**Subject:** Meeting Notes for NEPA/404 Merger Team Concurrence Point 4B  
TIP Project B-4929 (Topsail Island Bridge Replacement)

A NEPA/404 Merger Team meeting for the subject project was held on March 12, 2015 in NCDOT's Structure Design Conference Room. The purpose of this meeting was to reach agreement on Concurrence Point (CP) 4B (30% Hydraulic Review).

**Presentation:** Mr. Bollinger presented a PDF of the 30% redline drainage plans, and discussion included the following:

# INFILTRATION BASIN NO. 3 DETAIL

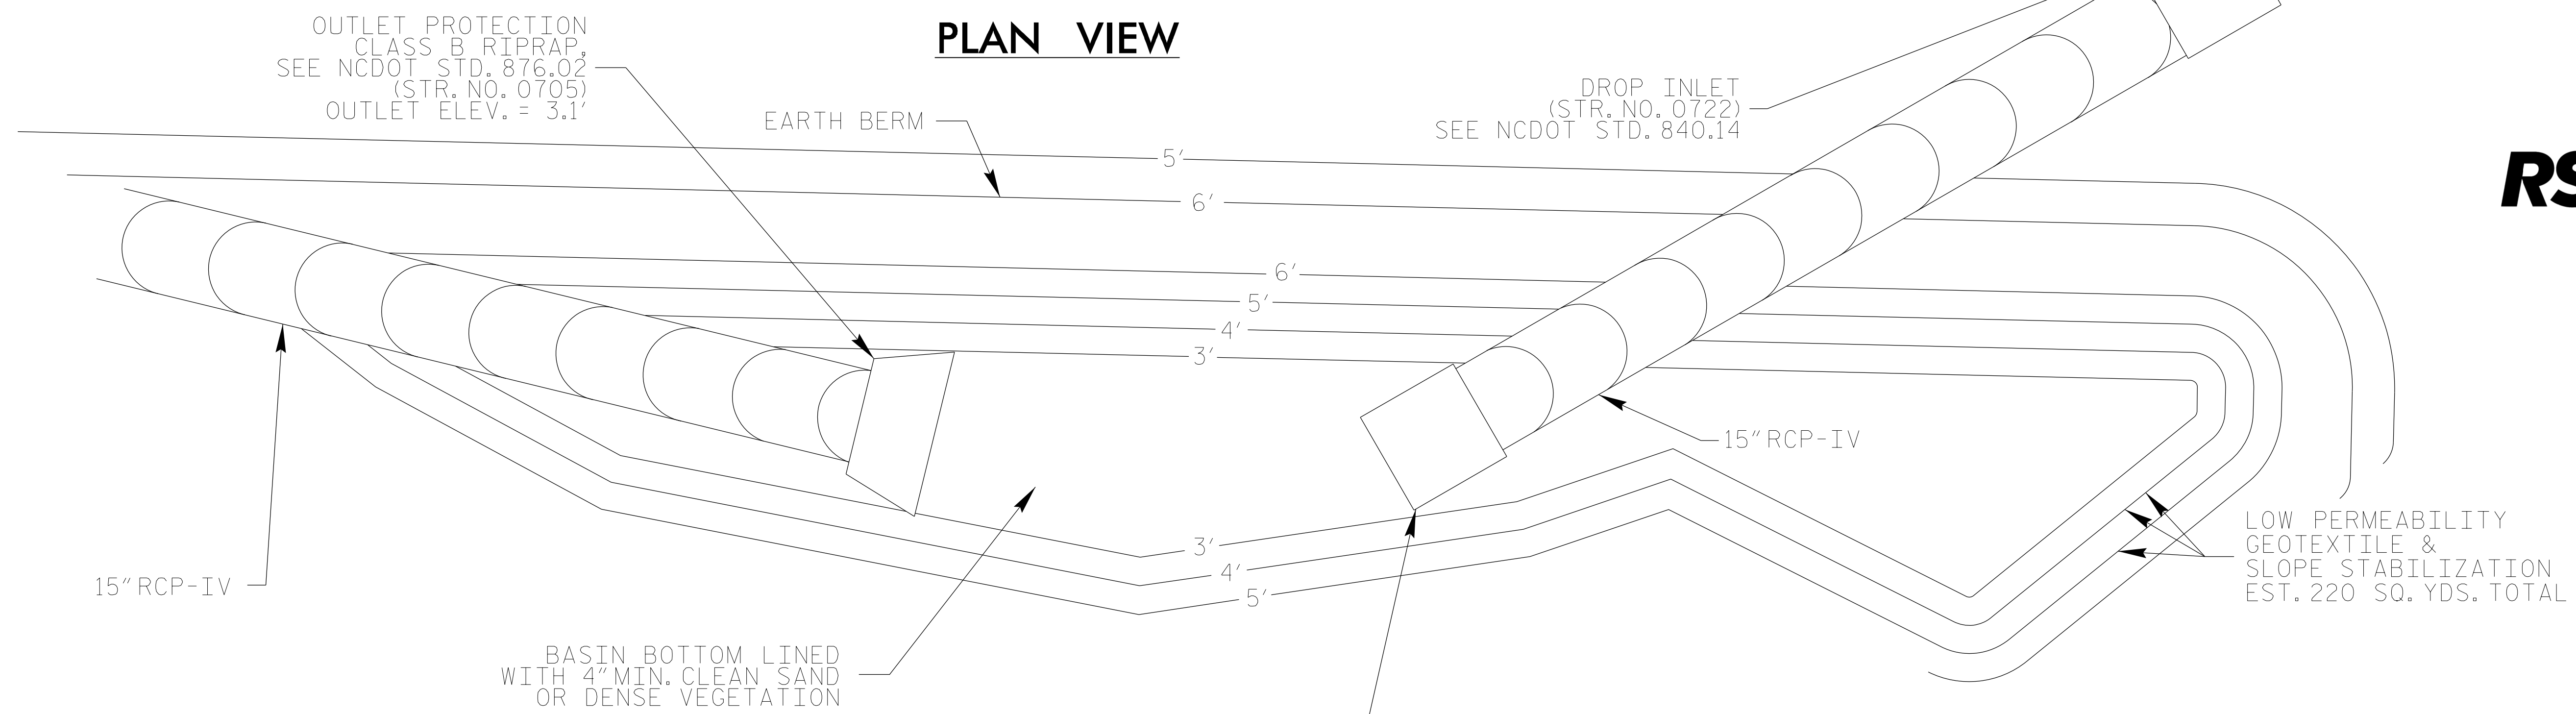
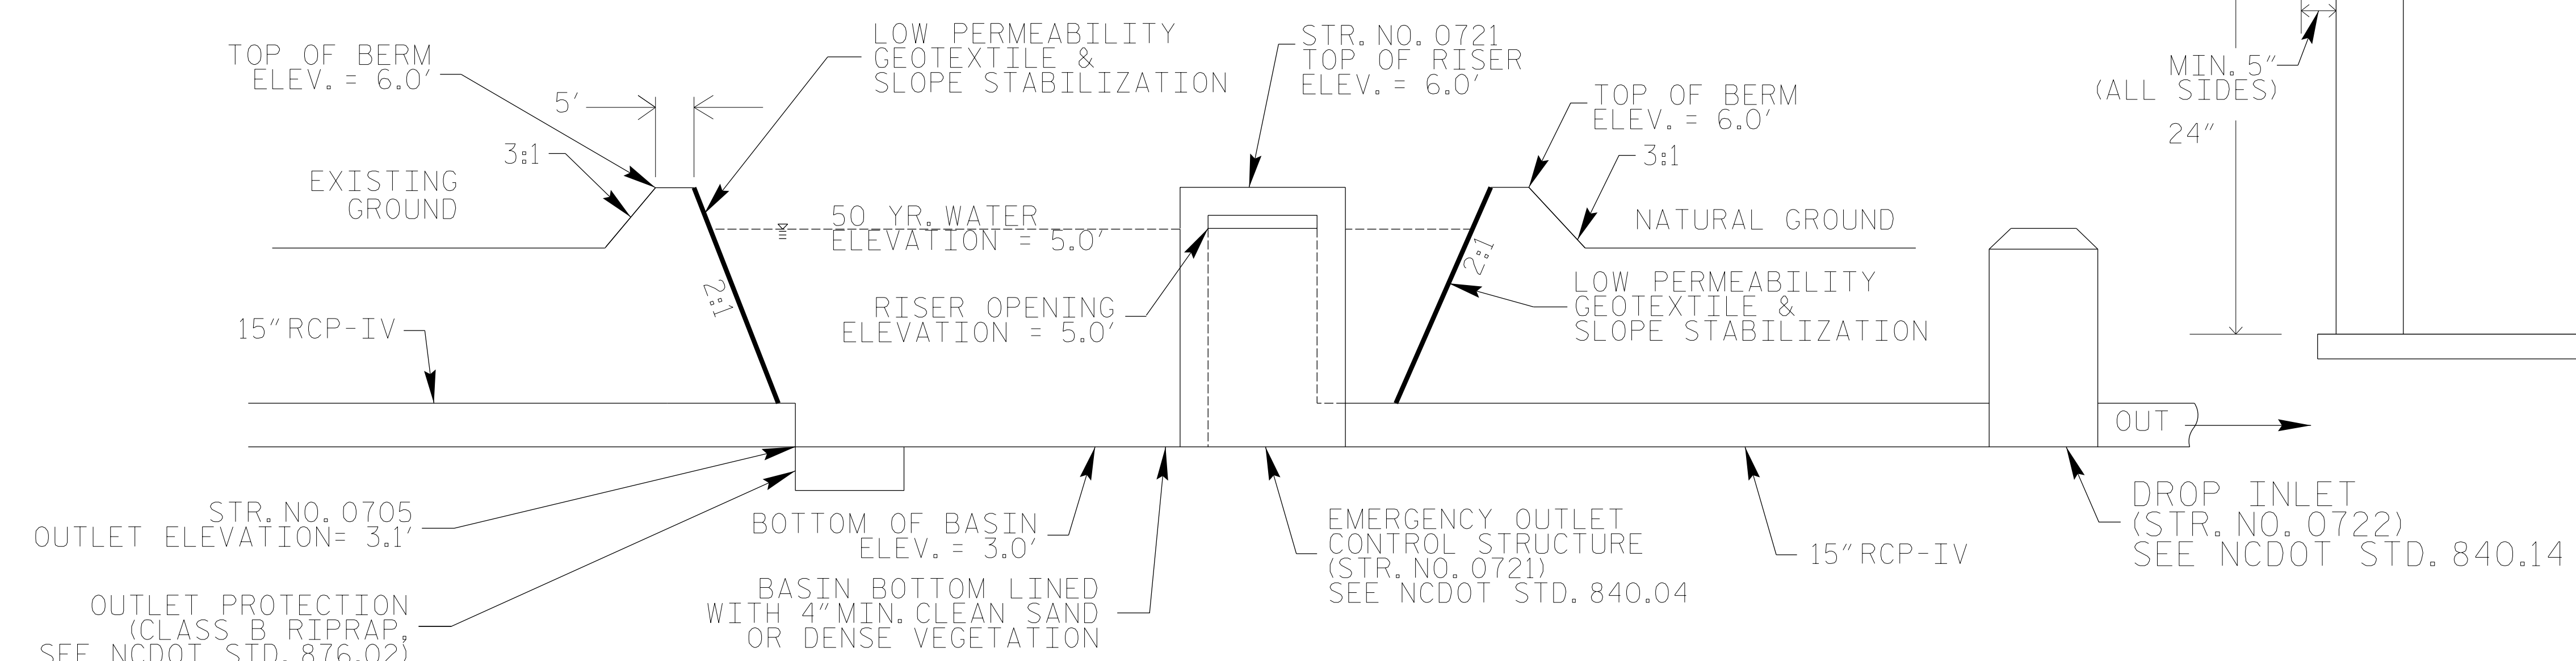
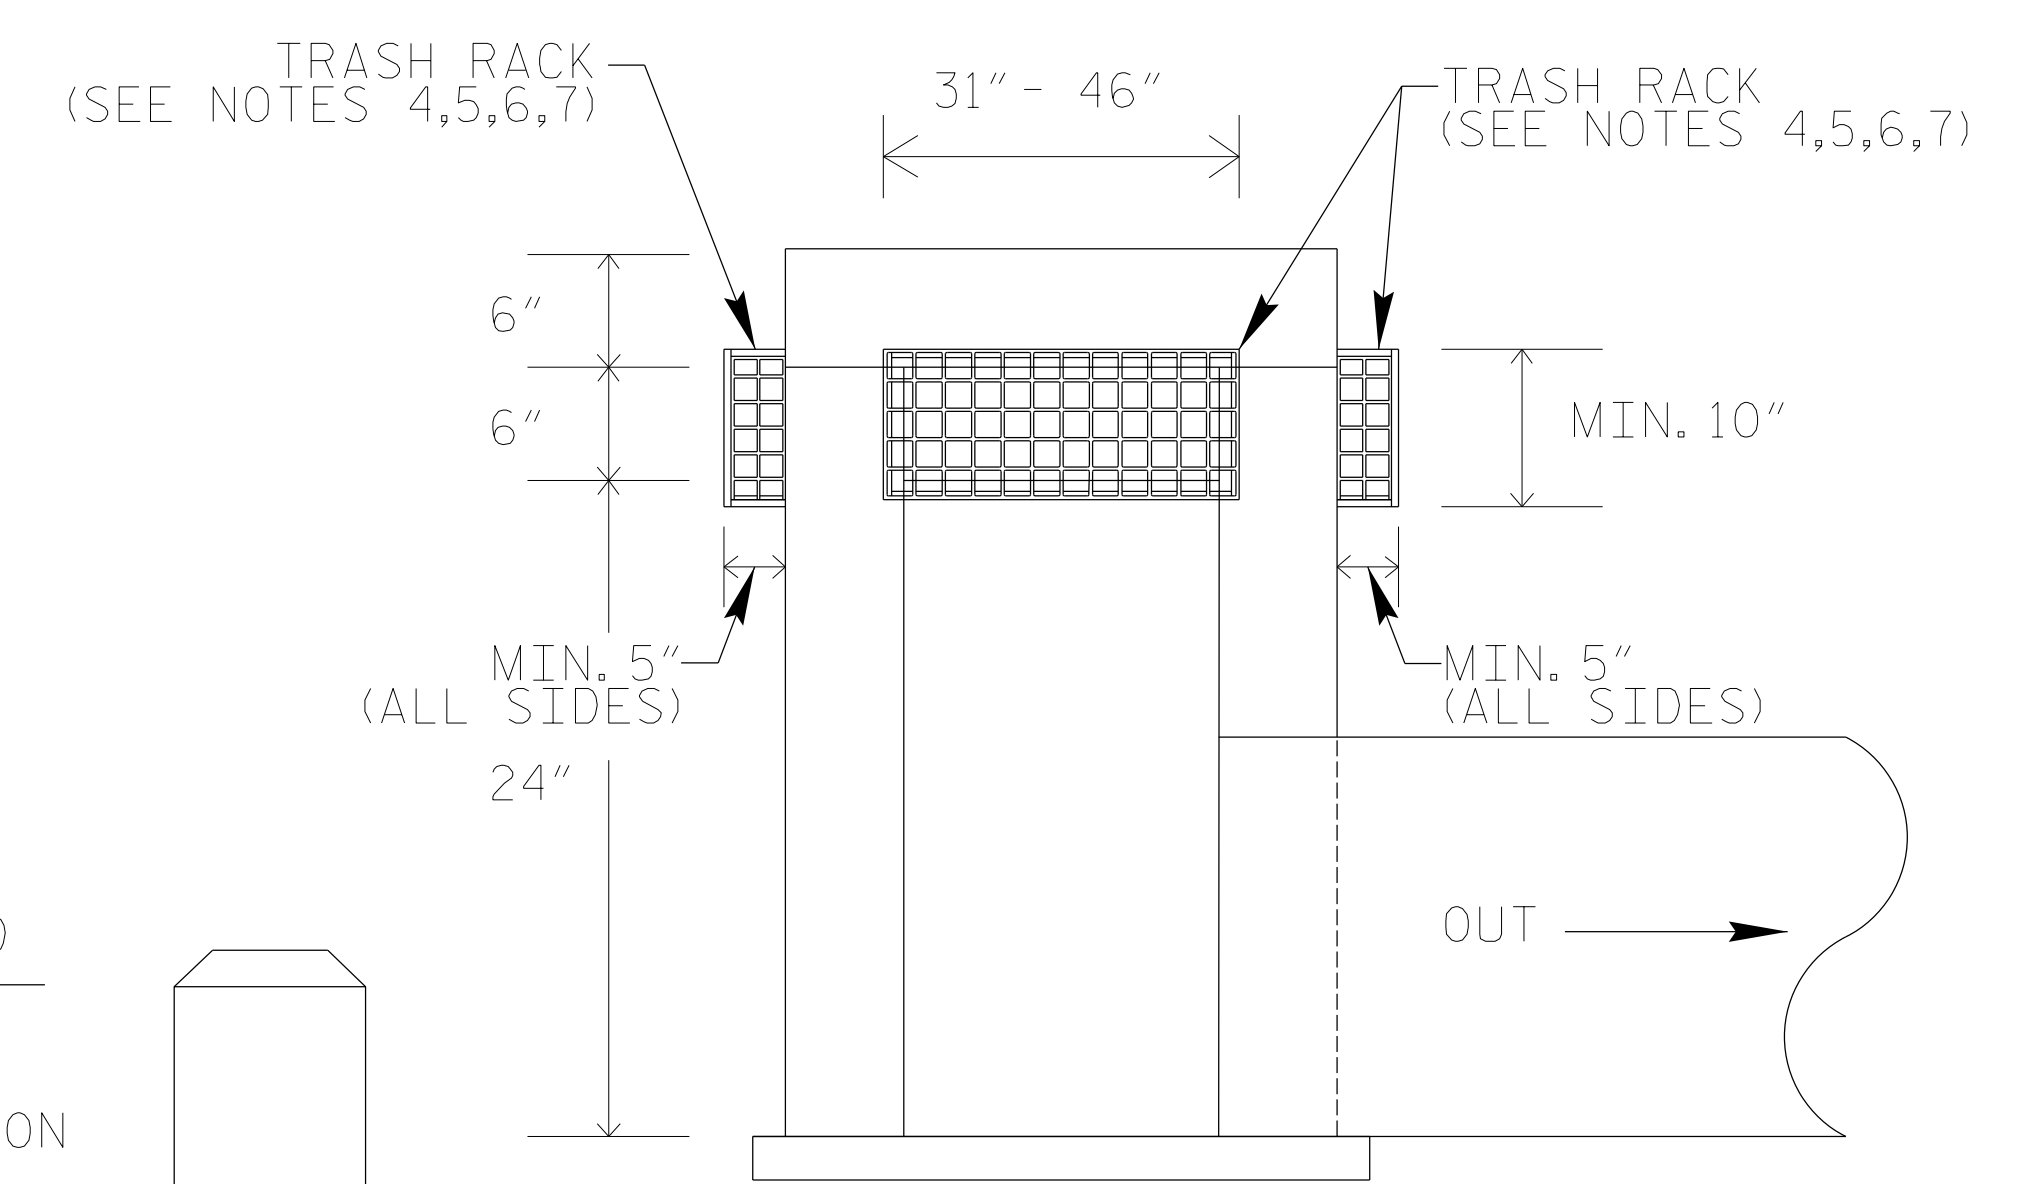
**MT Comment:** *Drainage basins should be located outside of wetlands and CAMA buffers (30 feet of the shoreline).*

**MT Comment:** *Mr. Herndon requested that NCDOT exhaust every option for treating all stormwater runoff from the bridge before proposing deck drains. MT attendees generally disapproved using deck drains over open water, particularly over Submerged Aquatic Vegetation (SAV) habitat.*

**PT Response:** Noted. Basins shown on the 30% hydraulic plans are subject to change and will likely be resized/relocated to minimize impacts. SAV surveys are scheduled for the summer prior to construction, and NCDOT will further refine the hydraulic plans in upcoming months.
